**WELWYN HATFIELD BOROUGH COUNCIL  
EXECUTIVE DIRECTOR - PLANNING, PUBLIC PROTECTION AND GOVERNANCE**

**DELEGATED APPLICATION**

**Application No:** 6/2020/3405/HOUSE  
**Location:** 107 The Ridgeway Cuffley Potters Bar EN6 4BG  
**Proposal:** Garage and car port conversion, infill of covered passage and alteration of two dormers in roof over garage  
**Officer:** Ms Emily Stainer

Project		Proposed Garage Conversion and Alterations to 107 The Ridgeway, Northaw, Herts, EN6 4BG	
Working Title	Number	Revision	
Proposed Plans and Elevations.	2046	P01	
Date	Scale	Drawn	
16.12.20	1:100 @ A1	AGM

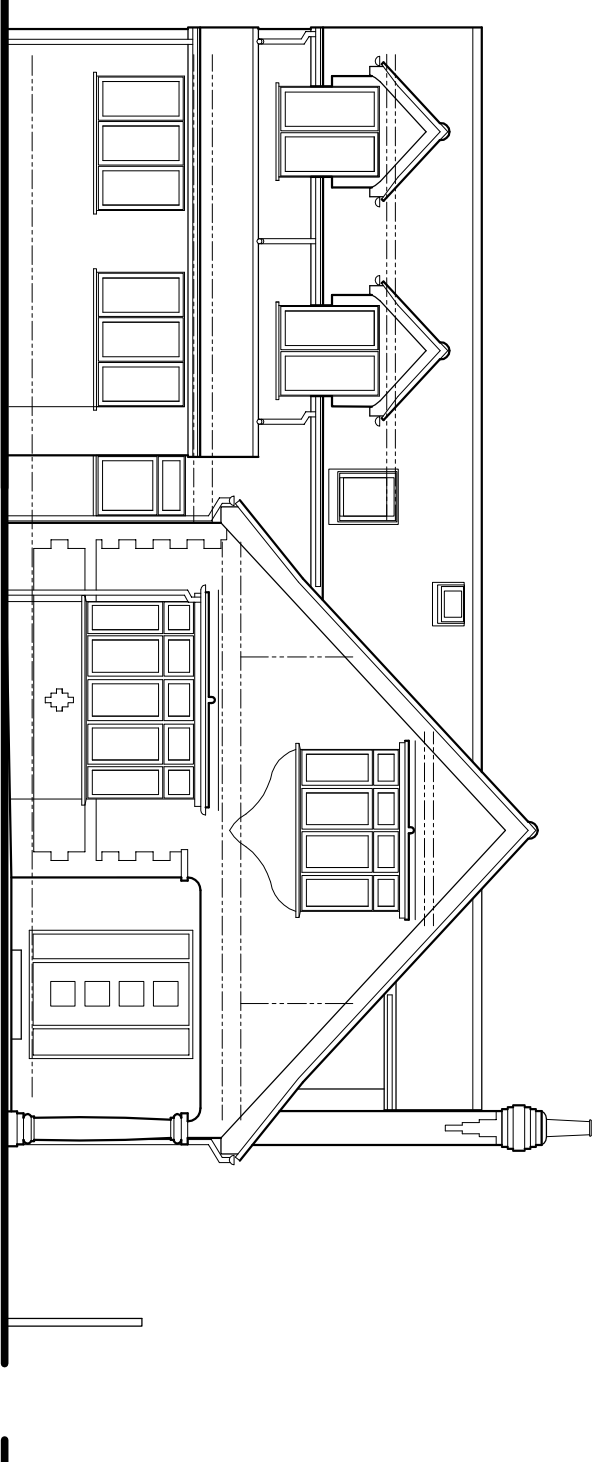
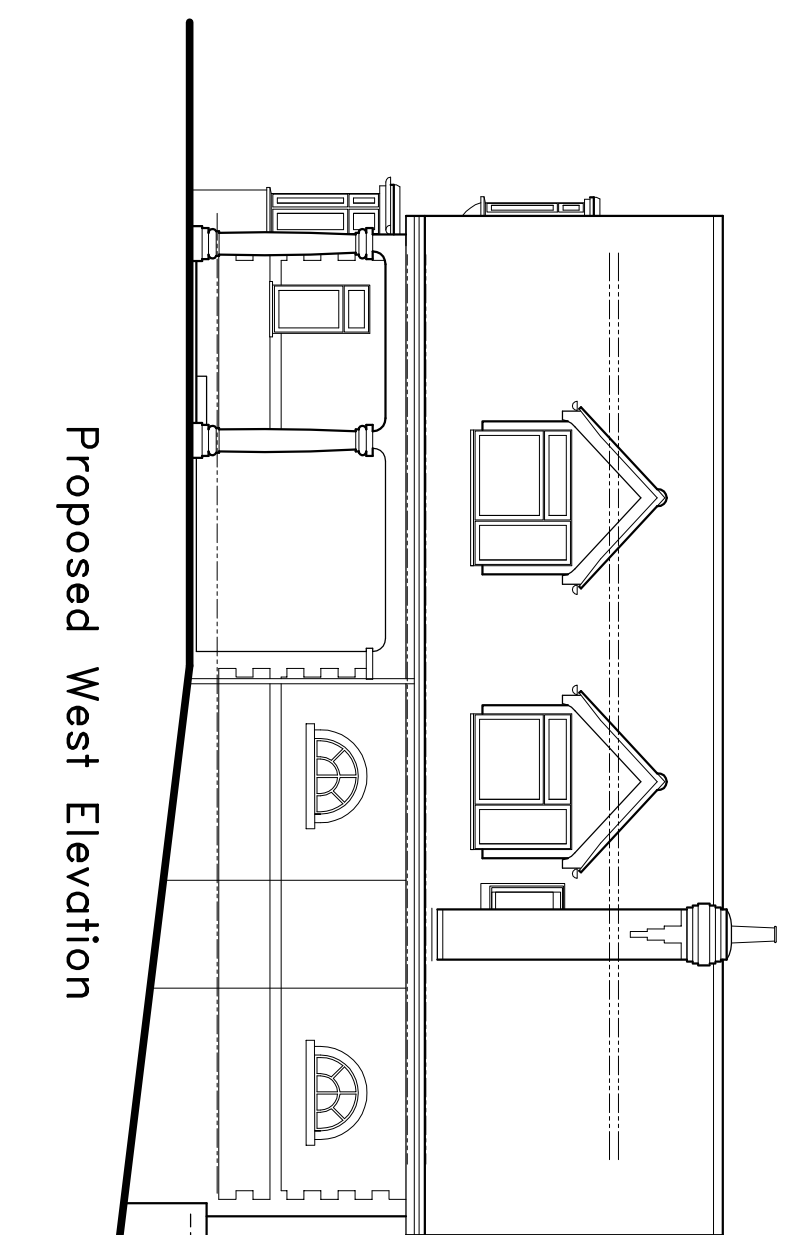
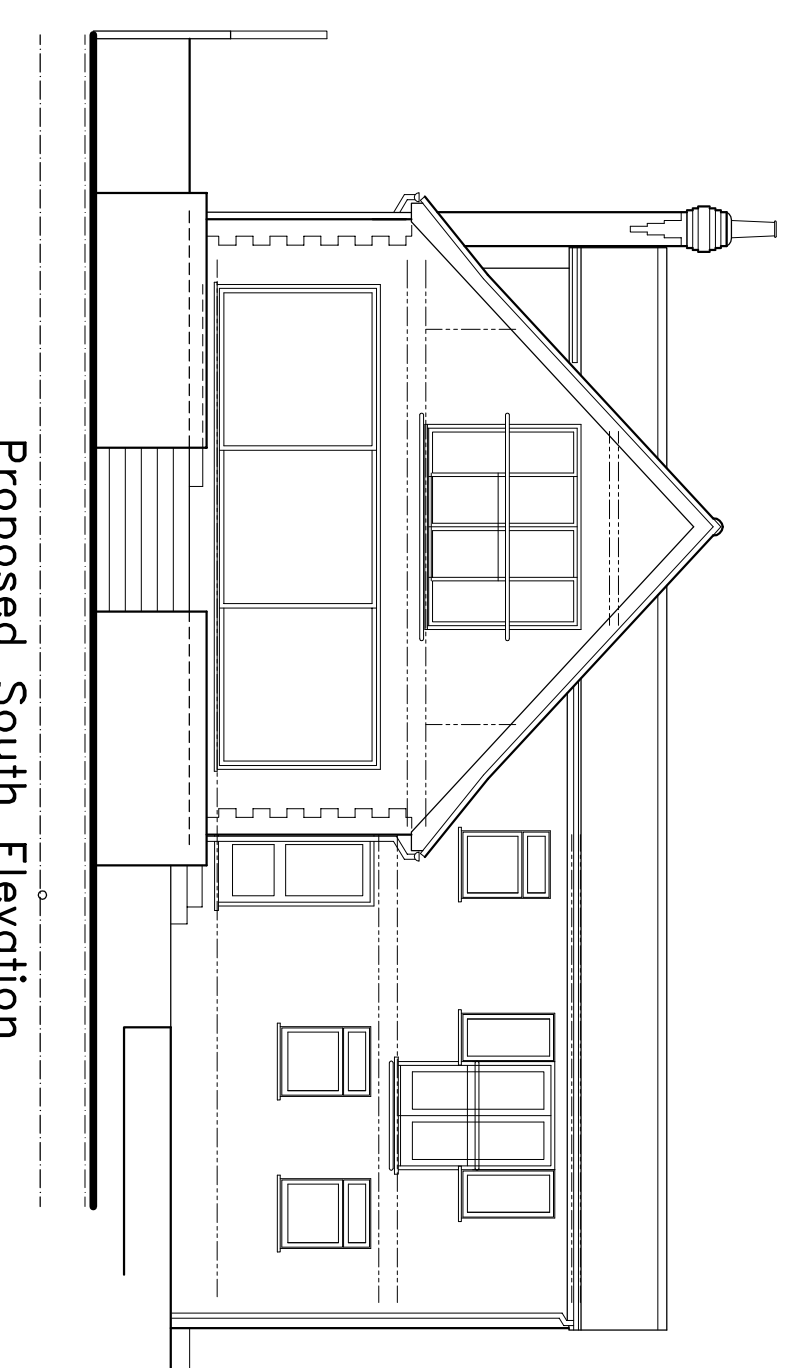
The SDG states that dormer windows should be contained within the roof slope, be subservient to the roof of the property and be in proportion to the existing fenestration of the property. They must not extend above the ridge height of the existing dwelling and the dormer cheeks should be at least 1 metre from the flank wall of the property or of the party wall with the adjoining property. Whilst the proposed dormer cheeks would not comply with the 1m guidance, they would be reduced in size compared to the existing flat roof dormers in this location and would appear adequately subordinate to the main property. Subsequently there are no concerns raised in this regard. The dormers would be finished with a pitched roof, and as there are examples of similar dormer windows in the surrounding street scene this is considered to be acceptable.

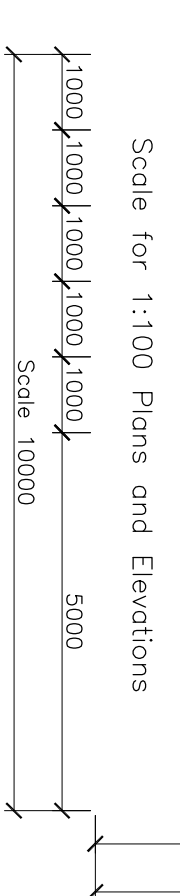
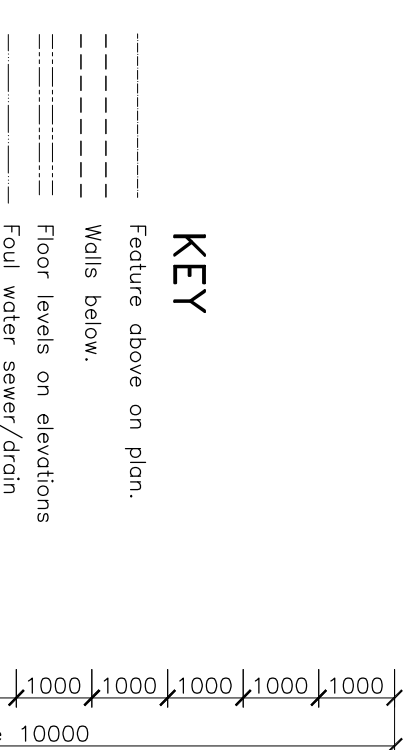
Whilst the proposed plans describe a 'high privet hedge changing to a 1350mm high brick wall topped by a 300mm high trellis' it has been confirmed by the applicant that this refers to the existing boundary treatment and will not be changed as a result of the proposal.
